Response to Planning application from Hertfordshire County Council (T and CP GDP Order 2015)

District ref: 6/2021/2125/MAJ
HCC ref: WH/8204/2021
HCC received: 27 July 2021
Area manager: Matthew Armstrong
Case officer: Samuel Tearle

HERTFORDSHIRE CONSTABULARY STANBOROUGH ROAD WELWYN GARDEN CITY AL8 6DF

Partial redevelopment of the Hertfordshire Constabulary Headquarters site

VGA PROJECT NUMBER	7645	LAL			
DRAWING REFERENCE	HCHQ-VGA-XX-XX-DR-AR-00115	P07			
DRAWN / DATE	CB SEP 20	CHECKED / DATE	MC JUN 21	SCALE	1:500 at A0 1:1000 at A2

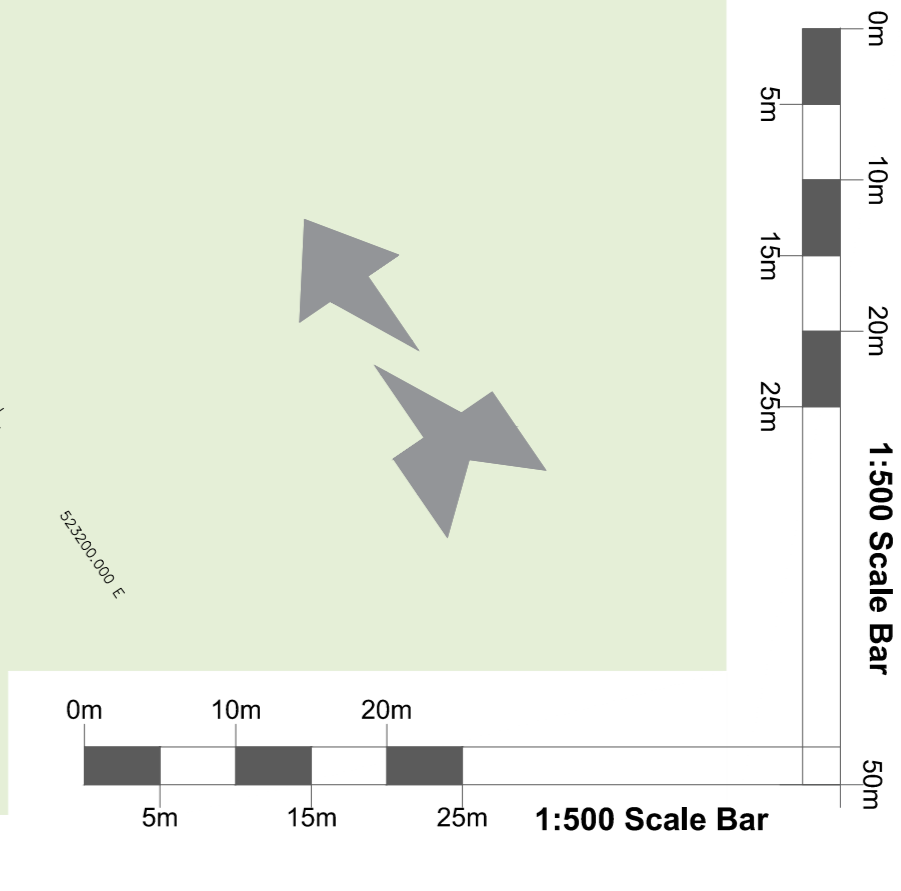
The proposed site masterplan, as shown on Drawing No. DR-AR-00115 Rev P07, shows the retention of the existing site access arrangements.

The Highway Authority are satisfied with these arrangements.

The proposed site masterplan, as shown on Drawing No. DR-AR-00115 Rev P07, shows the retention of the existing footway that links the site to the shared footway / cycleway on Stanborough Road.

It is acknowledged that under the previous permitted application 6/2017/0504/FULL, the proposals included the provision of a raised table feature at the main access and the realignment of the shared footway cycleway on the southbound approach to the access. The current application does not include this provision, and the Highway Authority are satisfied with this omission as the previous application focused on minor amendments to the existing use at the site whereas the current application is a more fundamental change which introduces Herts Fire and Rescue service use. Considering this, and the anticipated increase in emergency vehicles, the existing design which gives emergency vehicles priority is considered suitable.
